OUT21/10841

**Hunter Power Project (Kurri Kurri Power Station (SSI-12590060)  
RTS**

Figure 5.1: Indicative depths of excavations and groundwater (two scenarios)

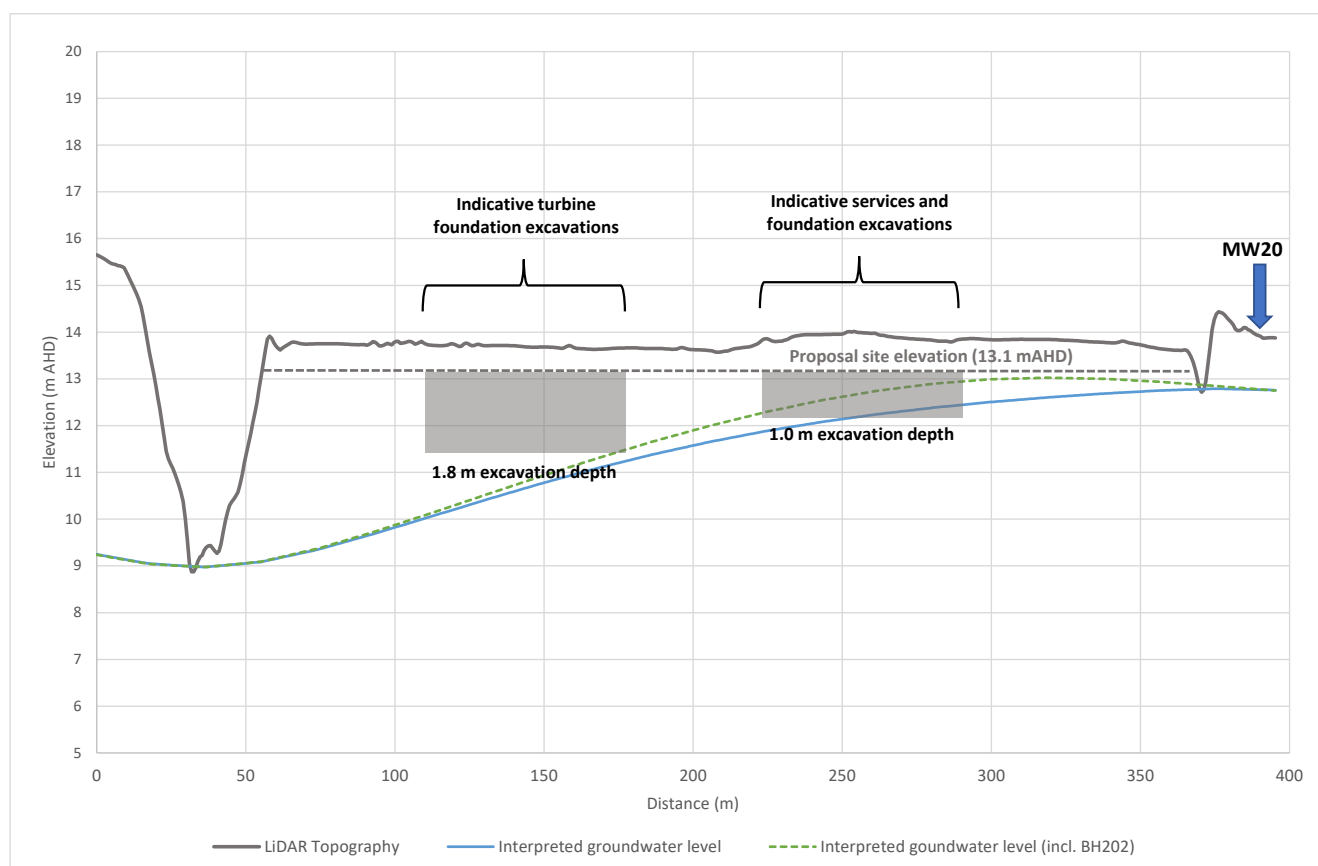
The majority of our issues raised in our EIS advice have been addressed. However the Proponent has not suitably addressed the potential interference of the surface water and pollution control basin with the aquifer and potential associated groundwater takes nor has addressed the potential risk for contamination from the same unlined basin.

1. that the proponent locate the base of the pollution and surface water management basin no less than 1 m above the water table, or
2. should the basin design intersects the water table:
  - a. A lining or similar measure to reduce potential for contamination or take of groundwater during construction and operation of the site is required. A commitment to that effect from the Proponent or a condition of approval to reflect this requirement is acceptable.
  - b. The proponent should provide estimated groundwater take related to construction and operation of the basin (prior to construction).
